## Planning Consultation Memo

<b>Date</b>	<b>Planning Officer</b>	<b>Environmental Health Officer</b>
03/07/18	William Myers	Karl Riahi
<b>Planning Application Number</b>	<b>Worksheet Number</b>	
6/2018/1153/FULL	WK/99479

**Address:** 8 Harpsfield Broadway Hatfield AL10 9TF

**Application Details:** Change of use of property from shop (A1) to ice cream/dessert parlour (A1/A3) and erection of single storey rear canopy seating area.

PROPOSED GROUND FLOOR PLAN

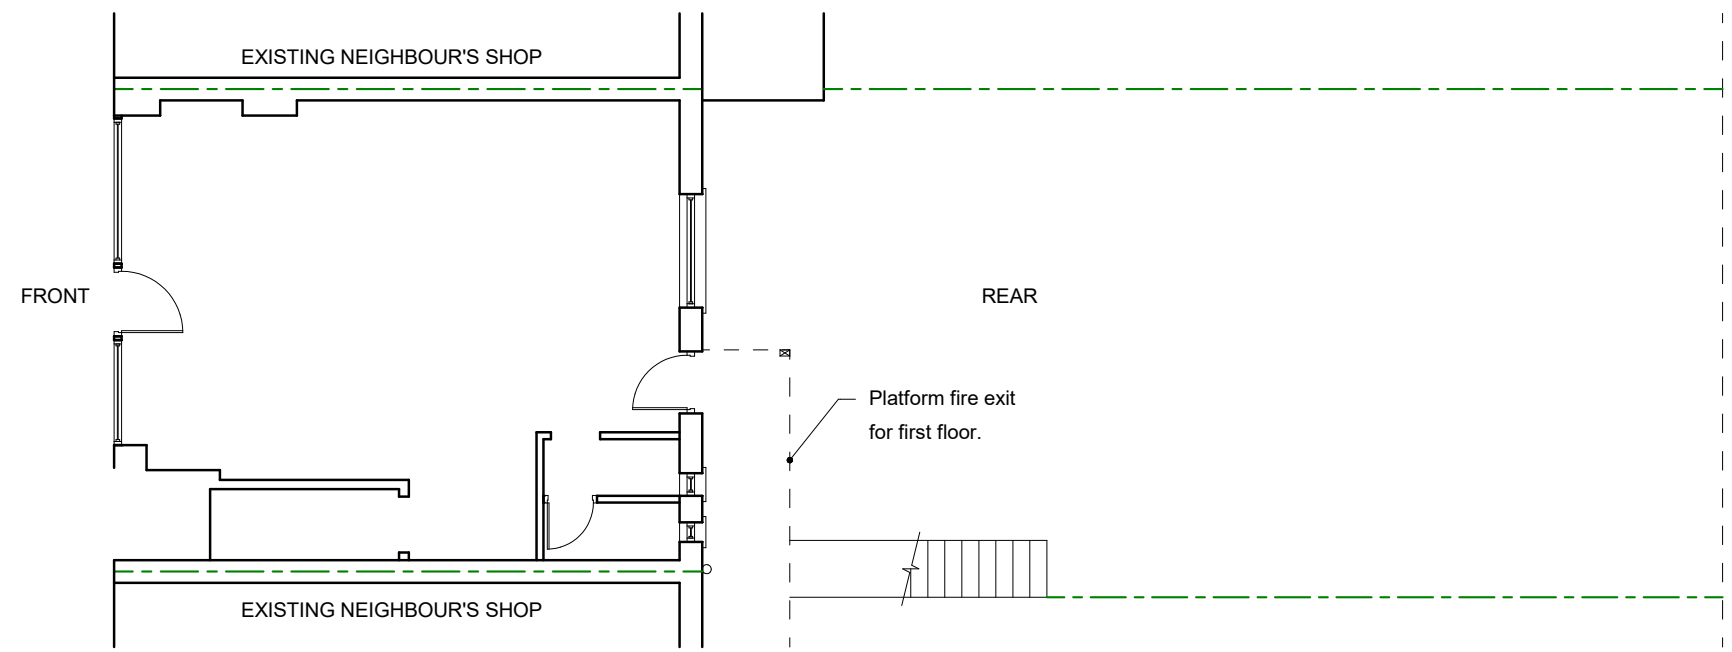
This will also need to encompass extract systems, however, looking at the plans, this does not appear to be a requirement for the business.

The toilet will need a lobby area as it will be opening directly onto where food is to be prepared. It is important to raise this issue at this time as the applicant will then be able to alter the layout of the premises to facilitate this requirement.
